From: Burland, James <[redacted]>
Sent: 07 October 2019 11:44
To: Anita Gardner <[redacted]>; Kevin Gale <[redacted]>
Subject: RE: M/32/19/PL - 46 Sea Lane, Middleton - amendment

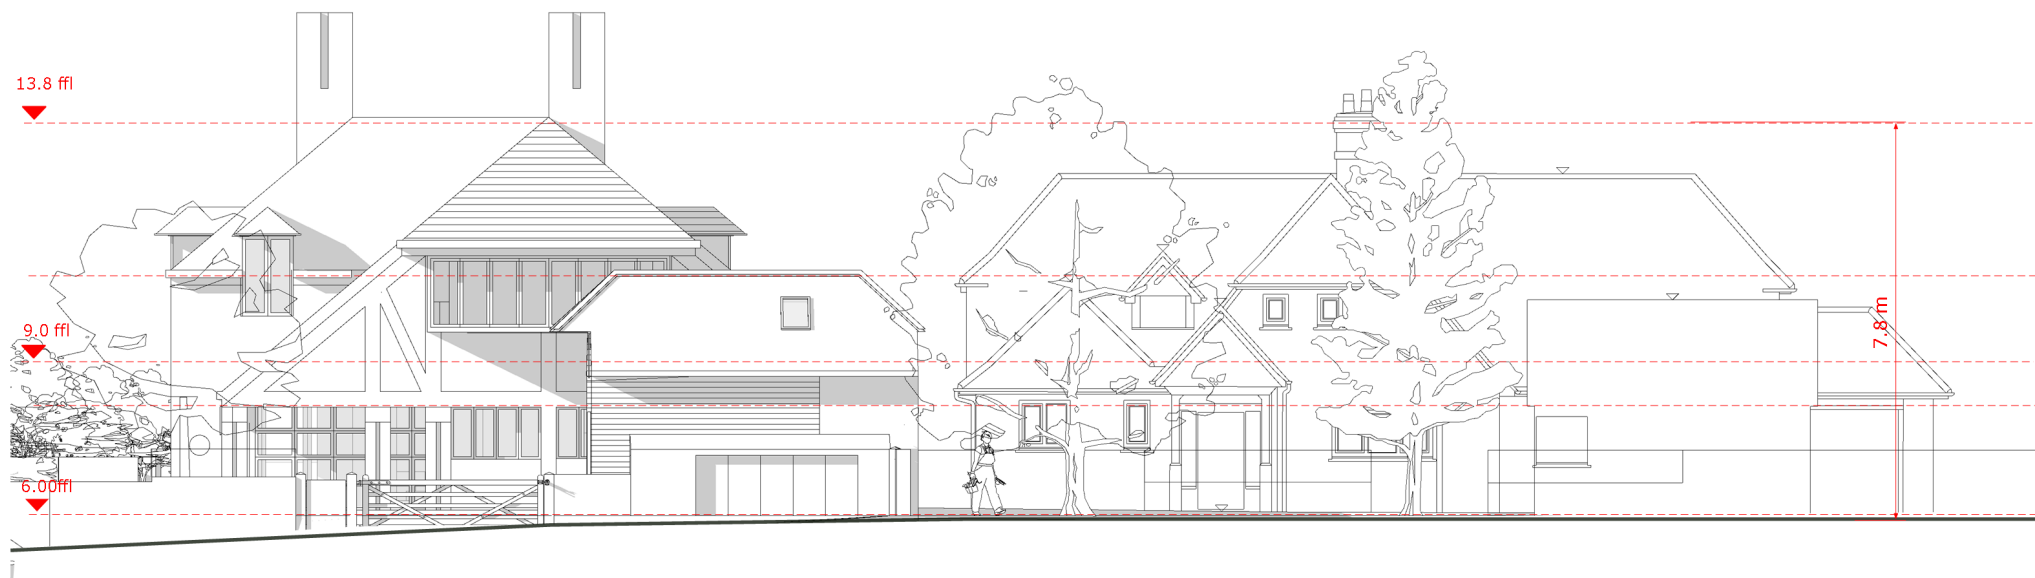
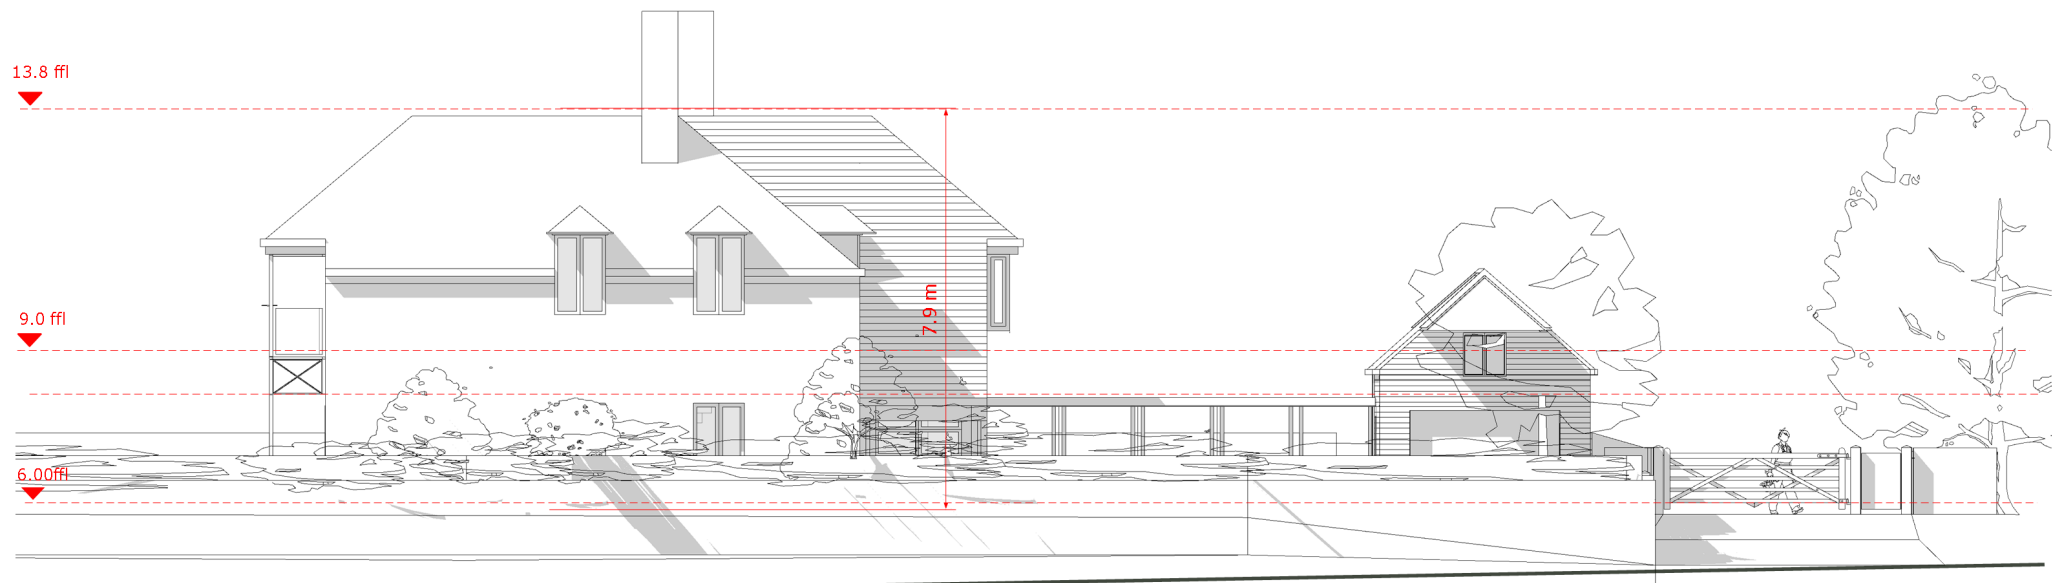
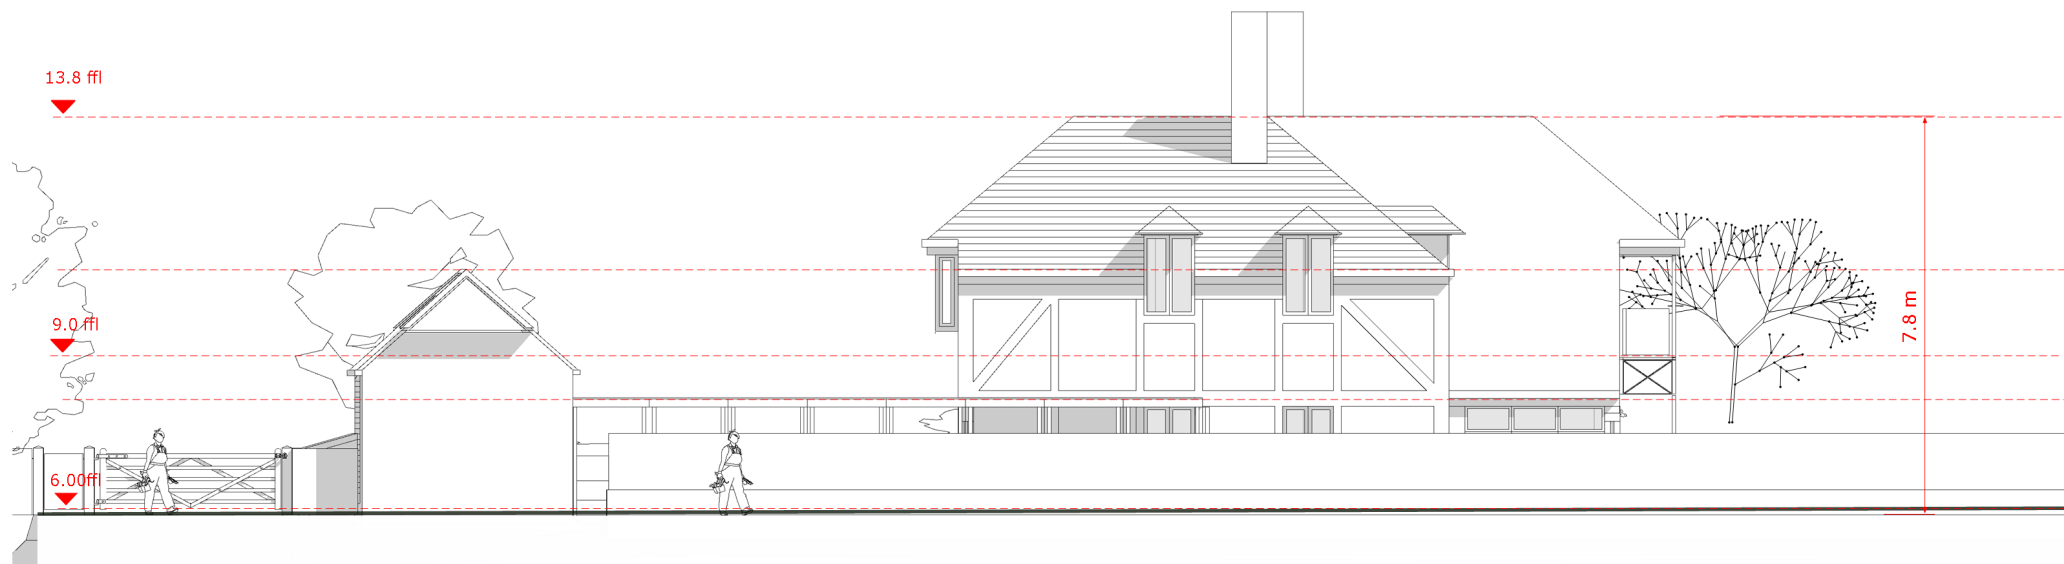
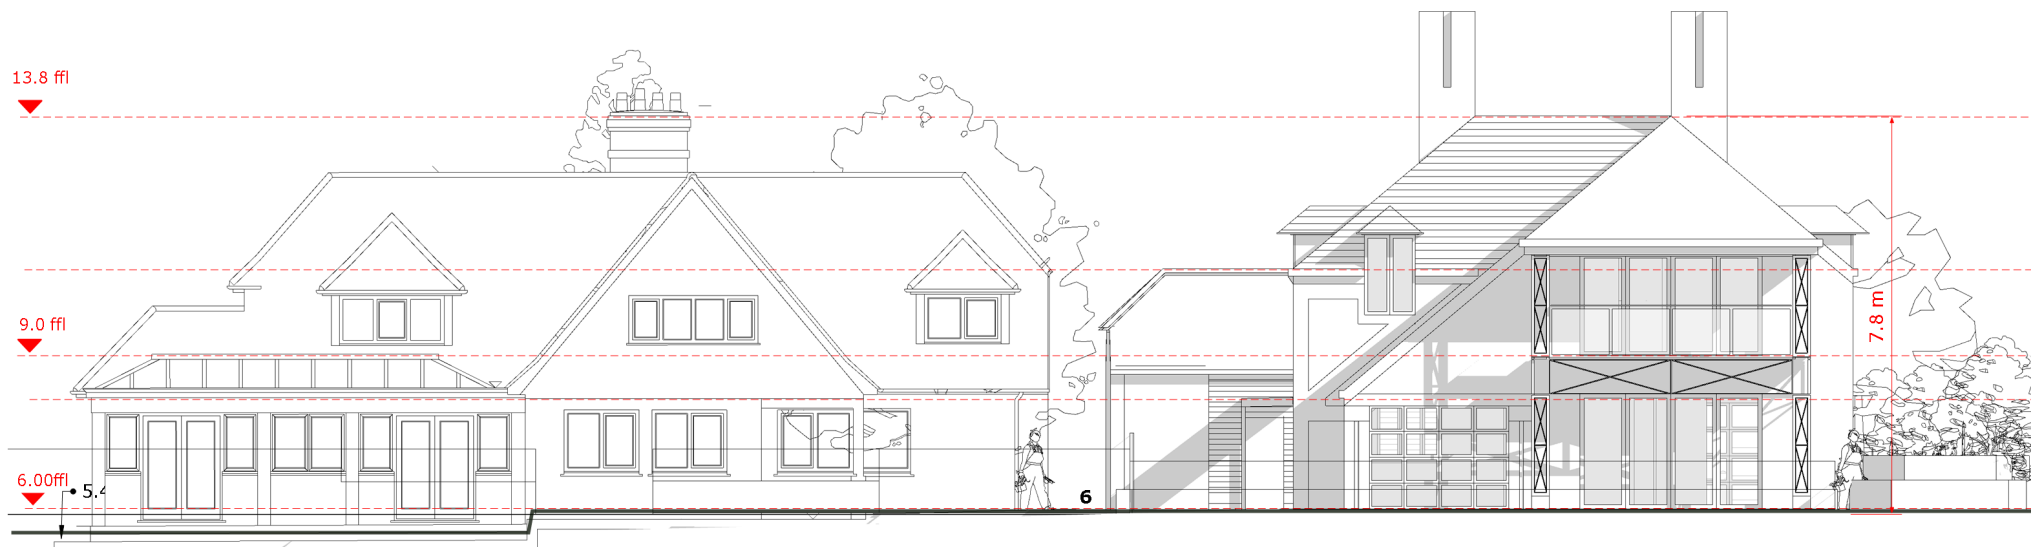
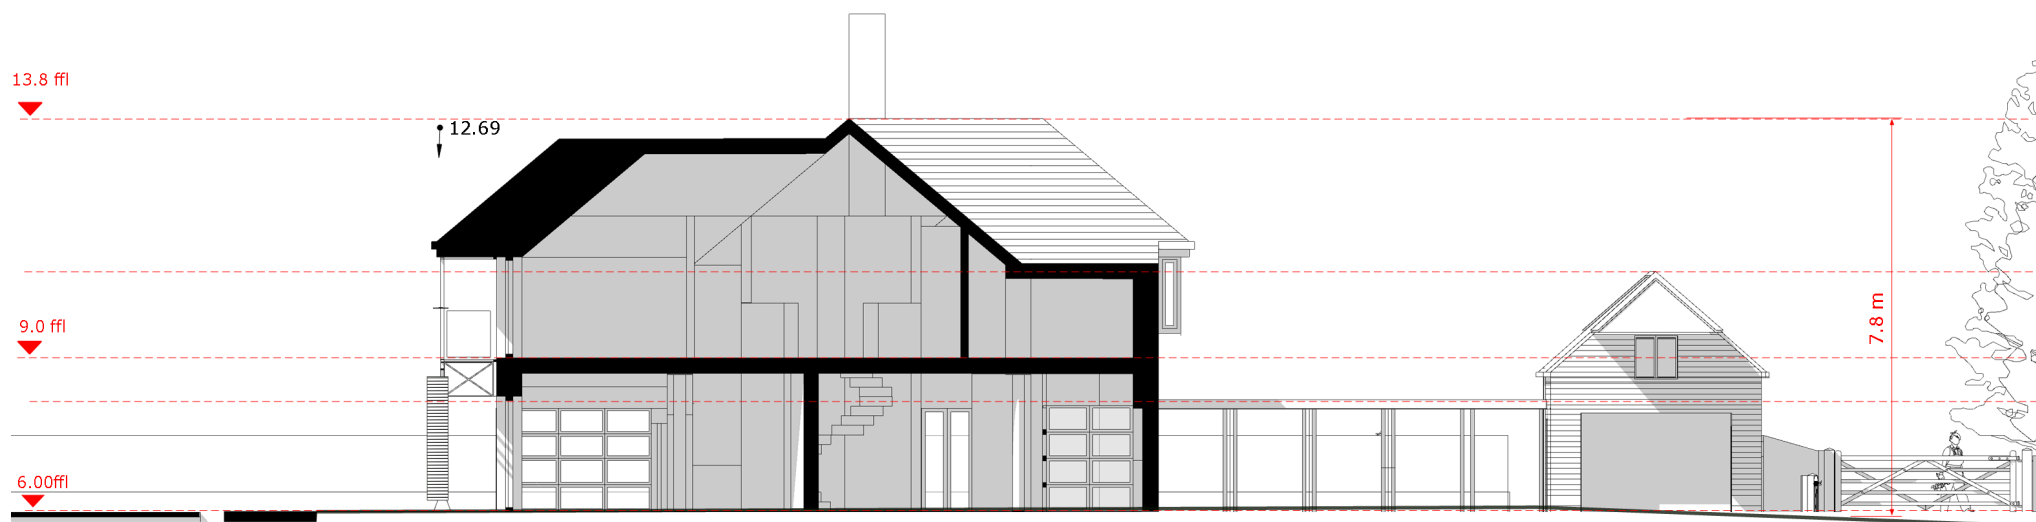
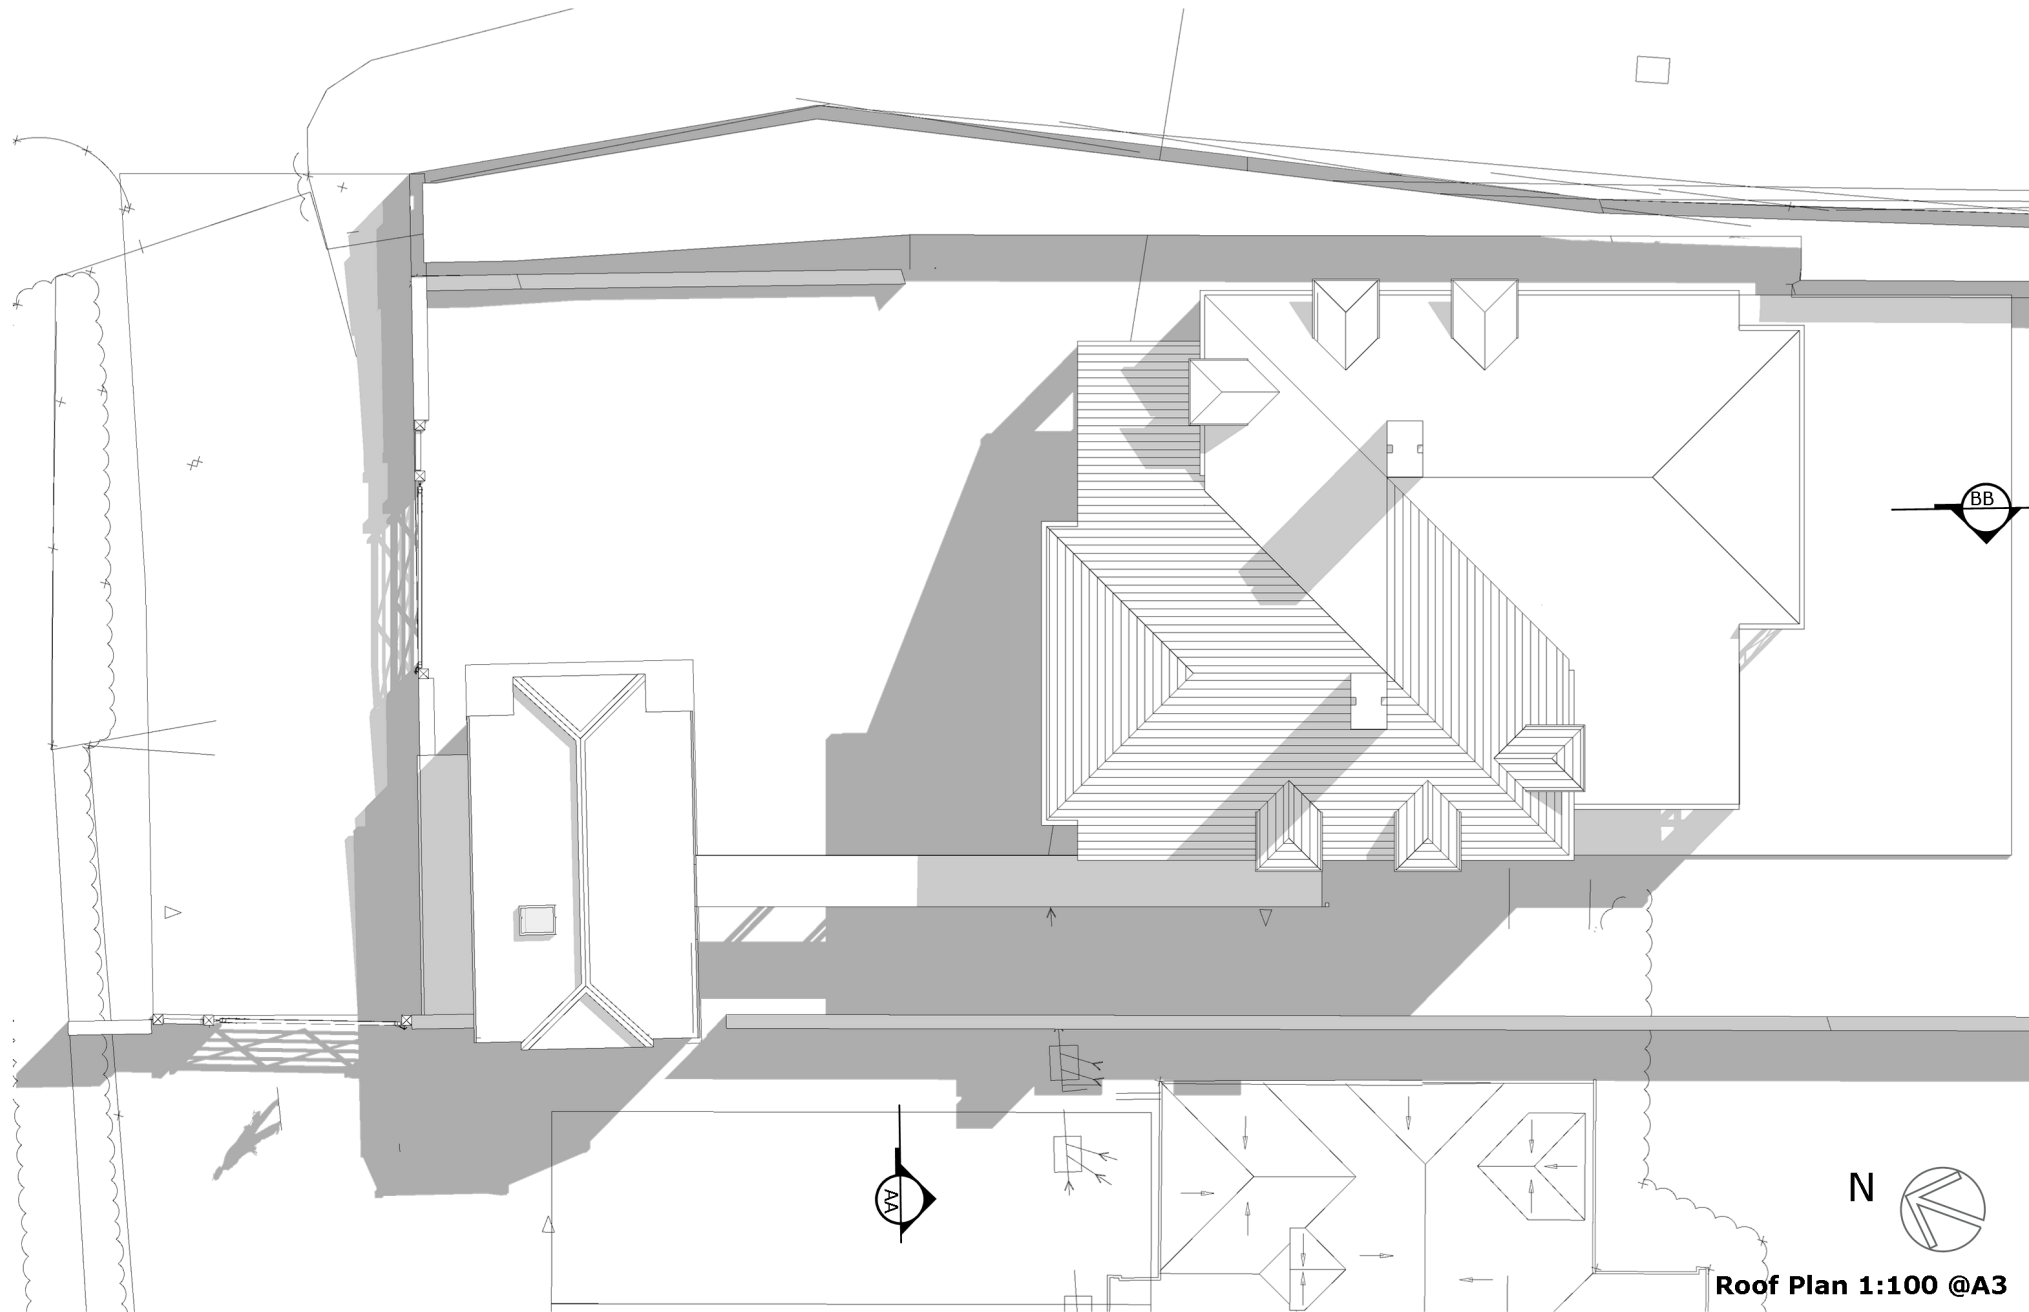
Thank you for your email 3 10 2019. Please find attached the revised drawings.
The form has been lowered by reducing the bedrooms and placing them in the roof to create a chalet style as suggested.
Please let me know if there is any further clarification required.
